Recommendation Report for Lawful Development Certificate for a Proposed Use or Development

REF NO: LU/162/19/CLP

LOCATION: Parkfield
Worthing Road
Littlehampton
BN17 6JN

PROPOSAL: Lawful development certificate for a proposed ground floor side extension, ground & first floor rear extension, rear dormer & front roof windows.

Date		Scale	
09/05/2019		1:50@A1	
Job no.	Dwg no.	Revision	
19/013	501	-

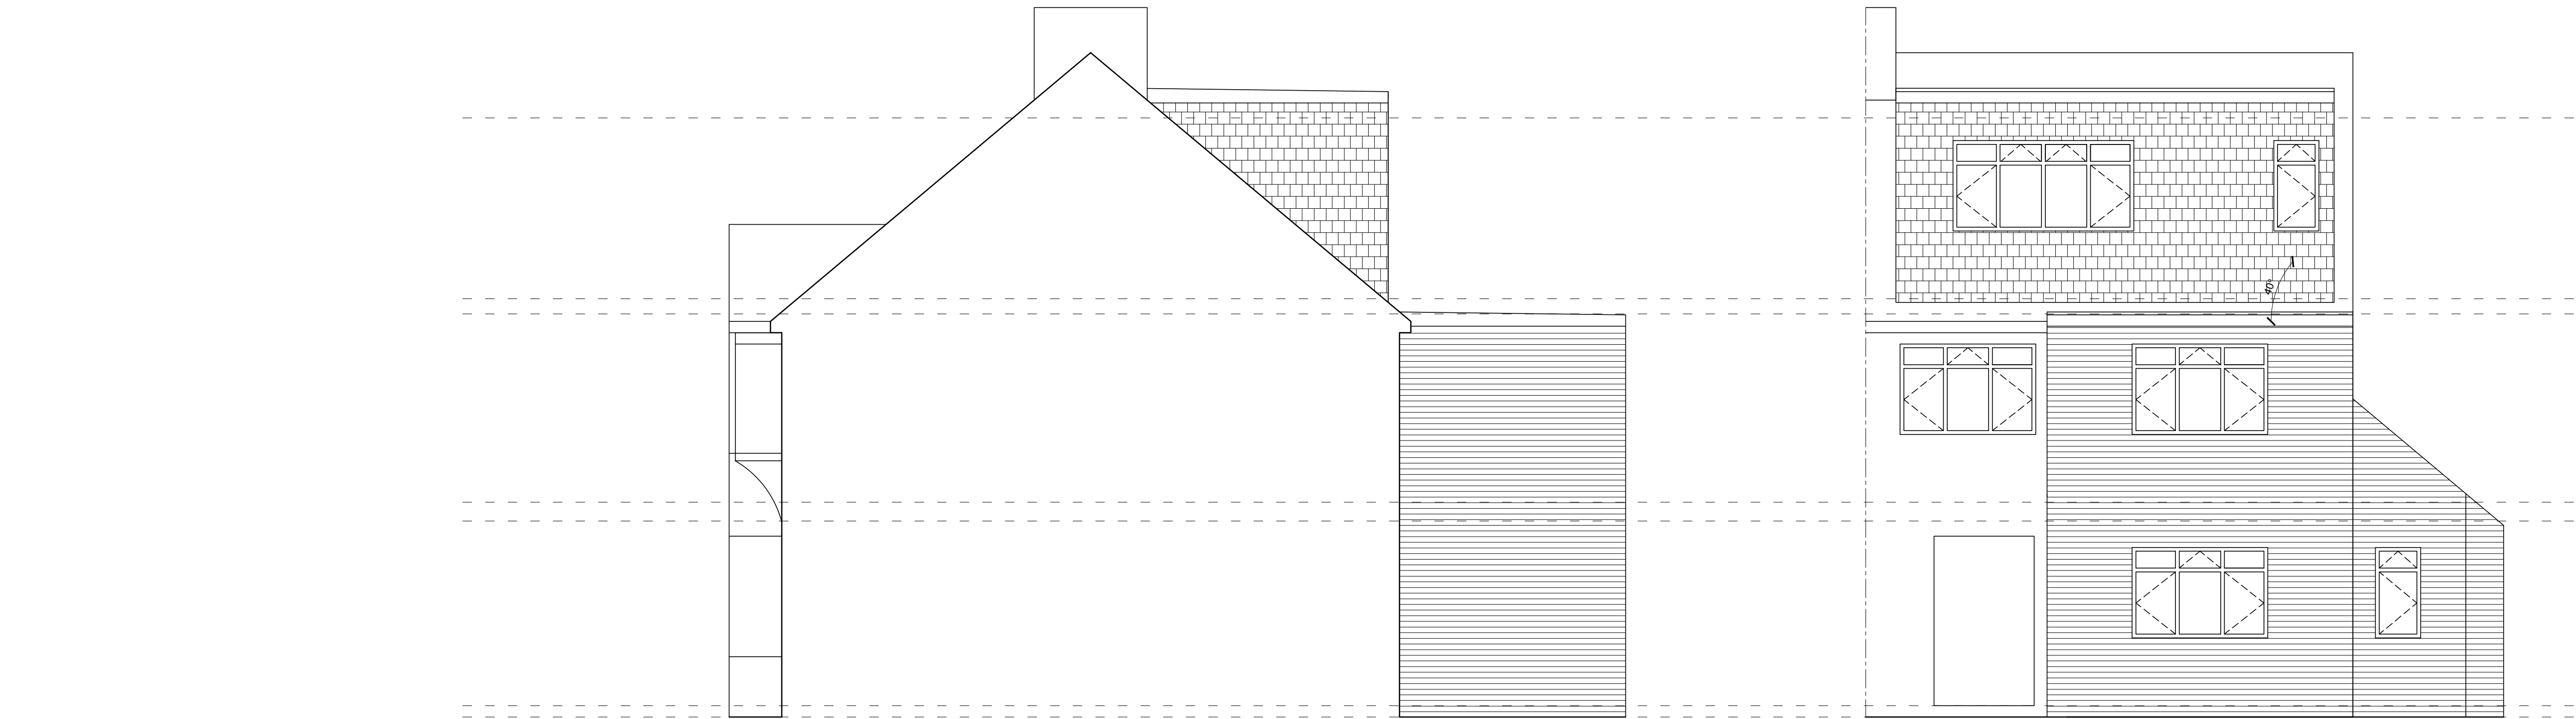
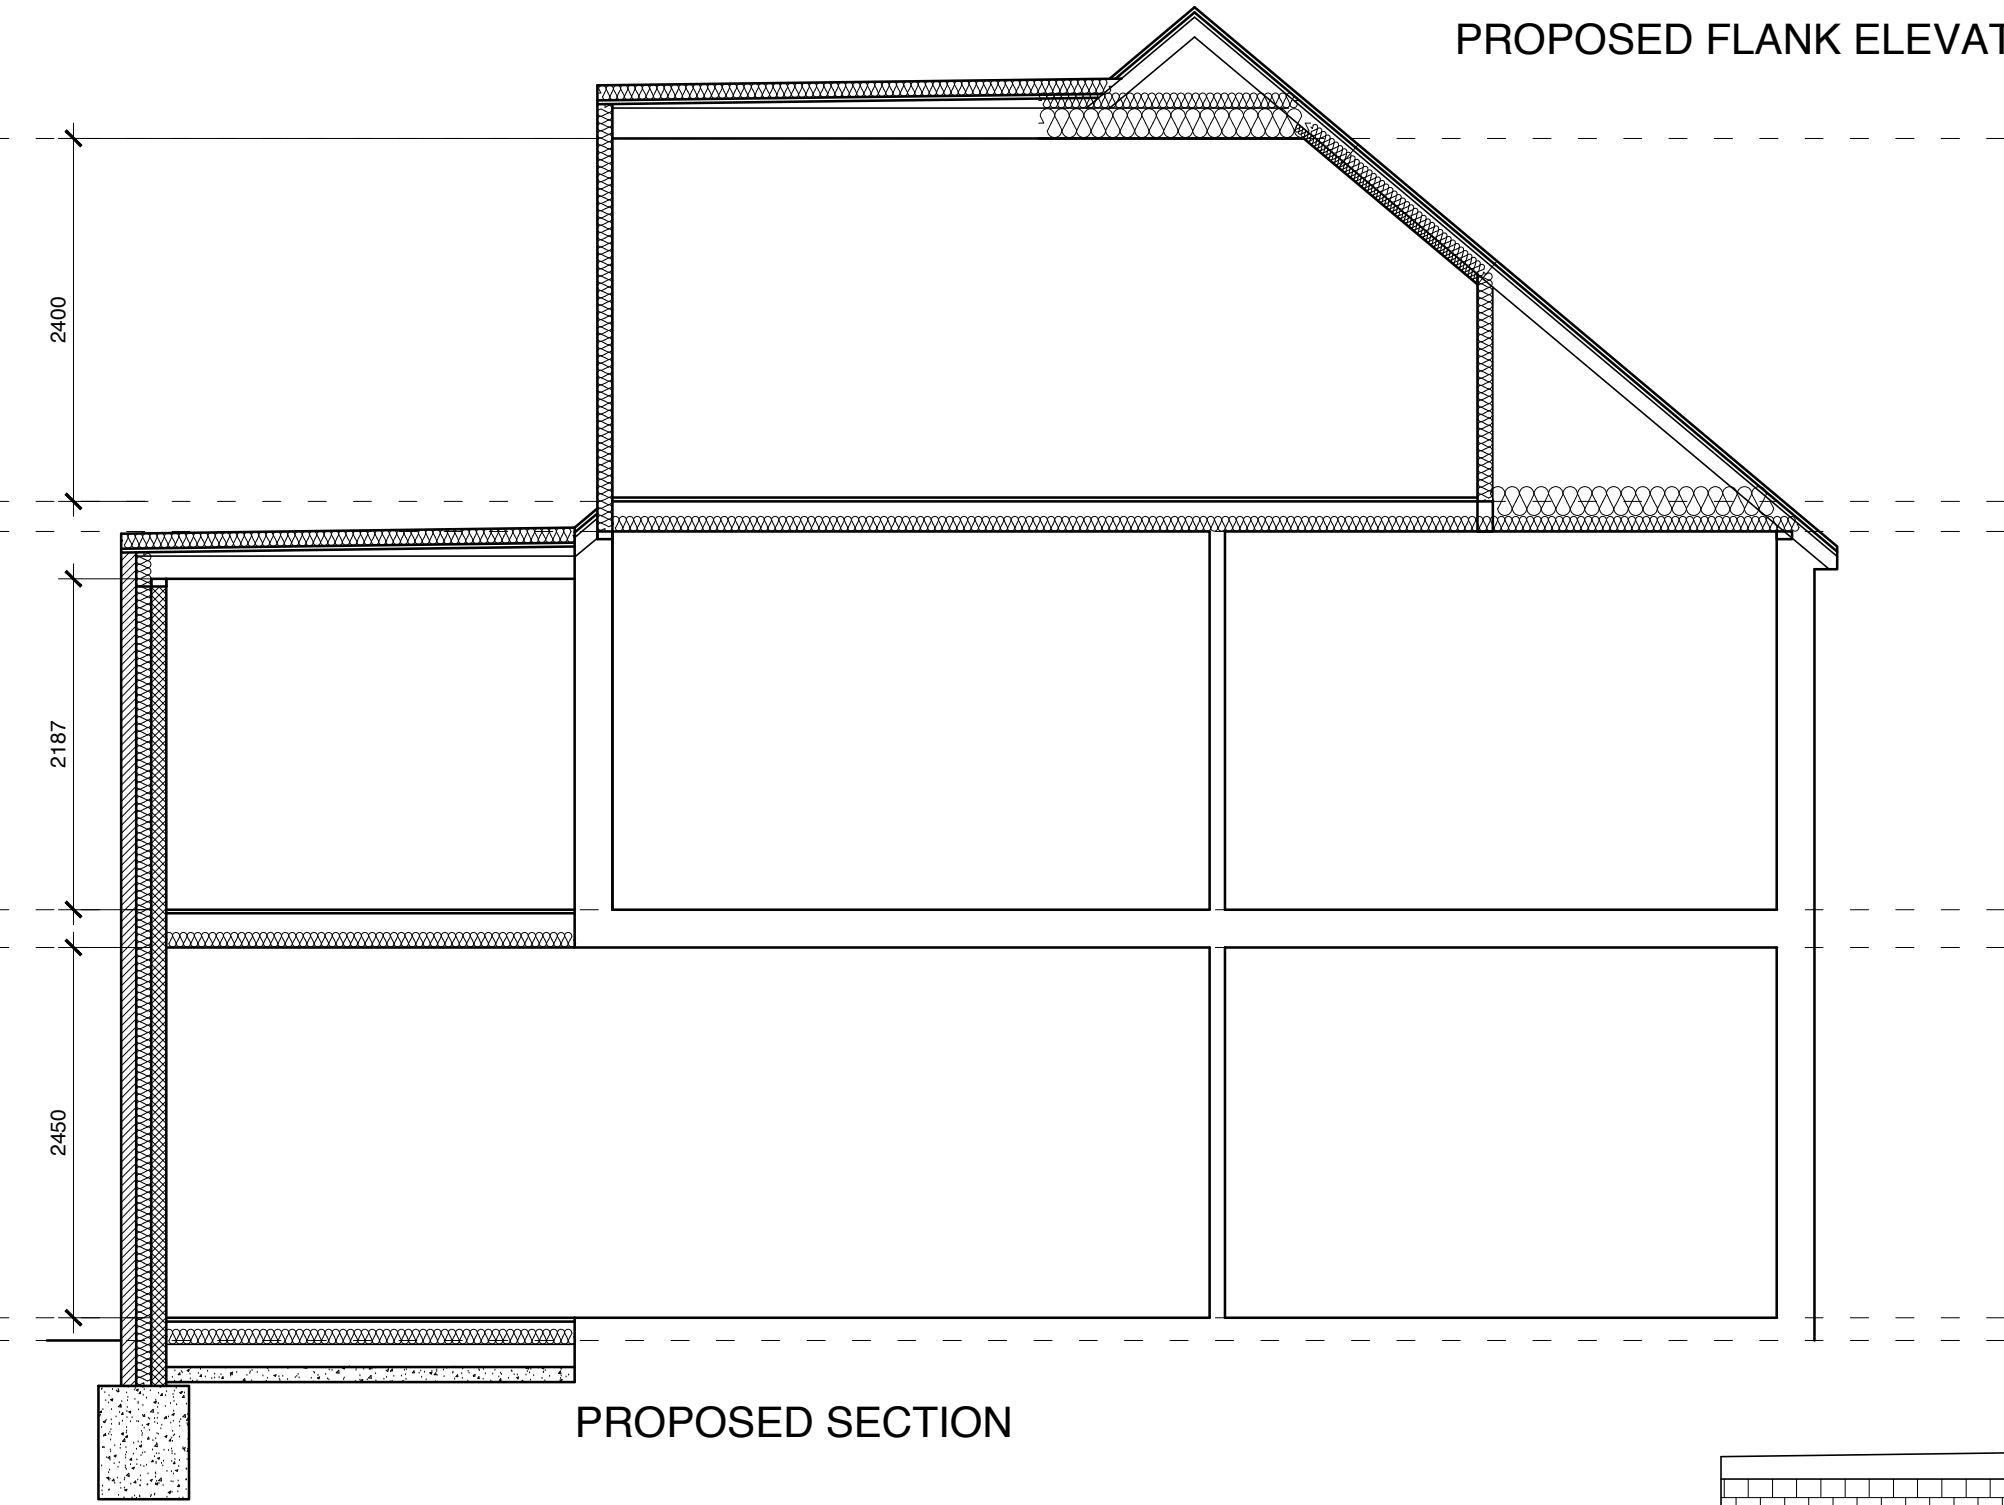
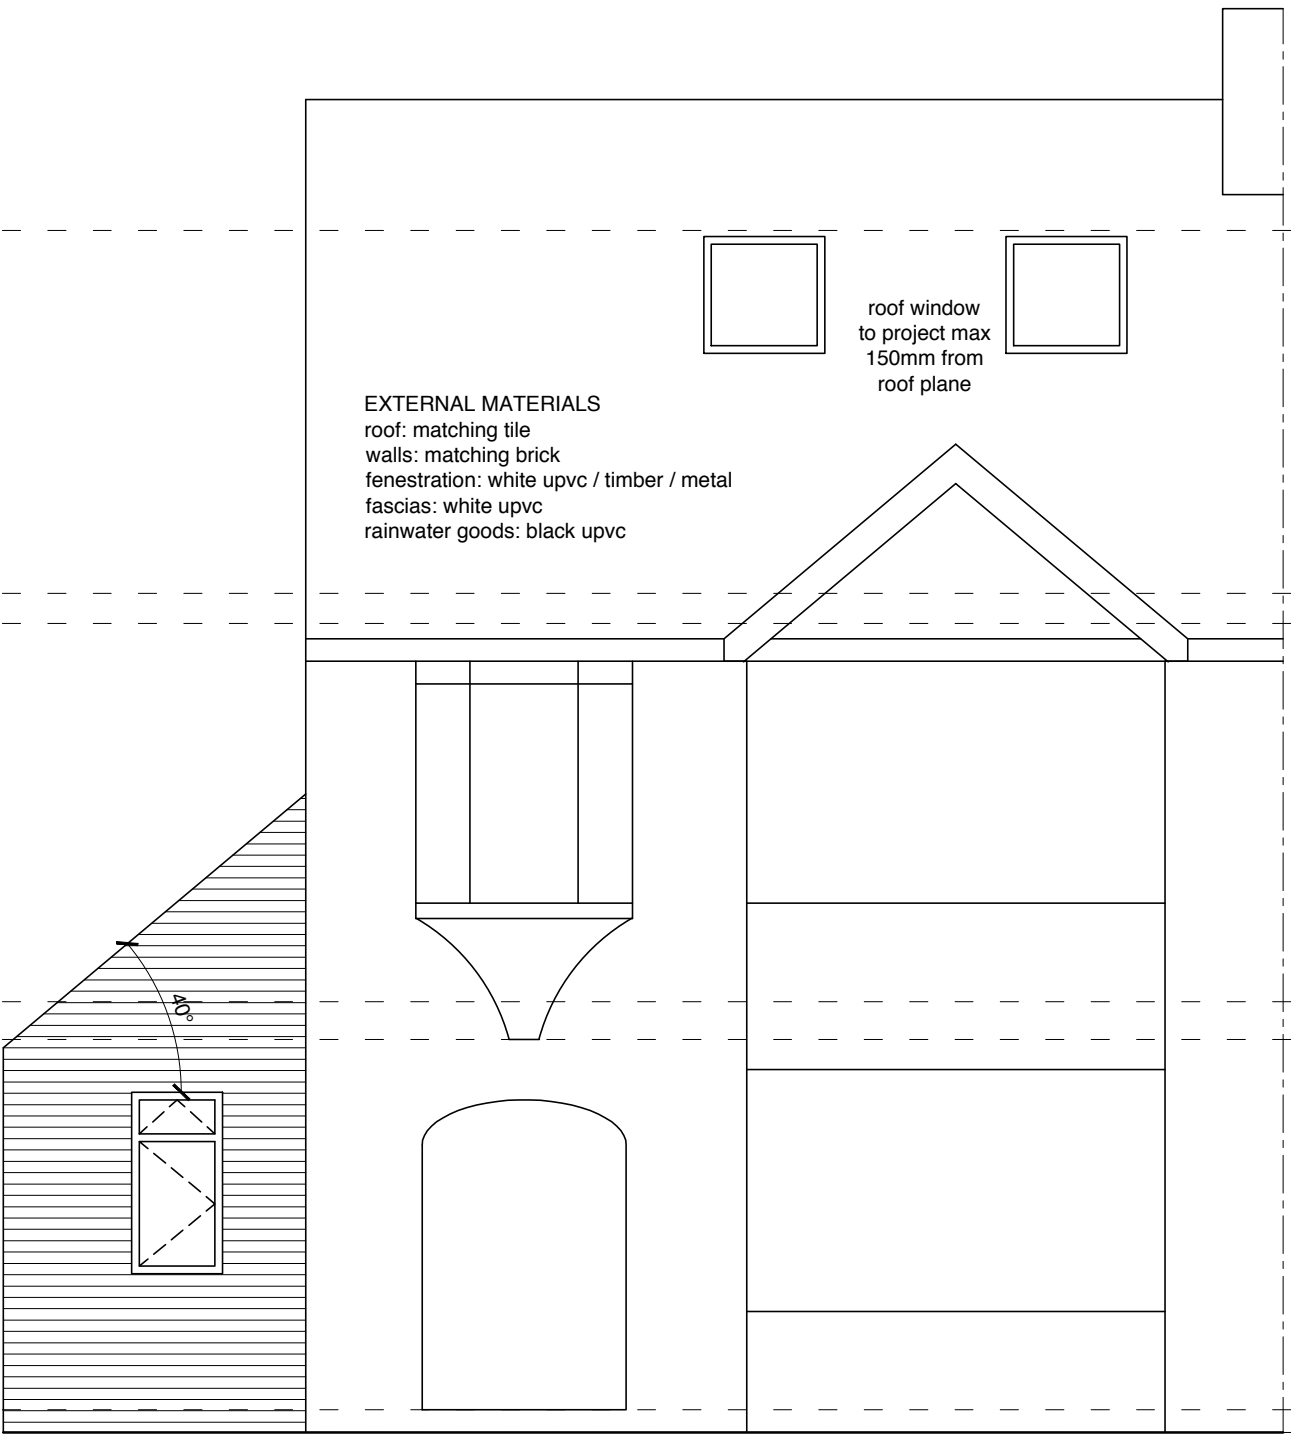
The proposed side extension is considered to conflict with Schedule 2, Part 1, Class A (j)(i) of the Town and Country Planning (General Permitted Development) (England) Order 2015, in that the maximum height of this element of the proposal is 4.2m high.

The majority of the proposal complies with the relevant sections from Class A, Class B and Class C and is considered permitted development and as such does not require the submission of an application for full planning permission. However, the proposed side extension is considered to conflict with Schedule 2, Part 1, Class A (j)(i) of the Town and Country Planning (General Permitted Development) (England) Order 2015, in that the maximum height of this element of the proposal is 4.2m high.
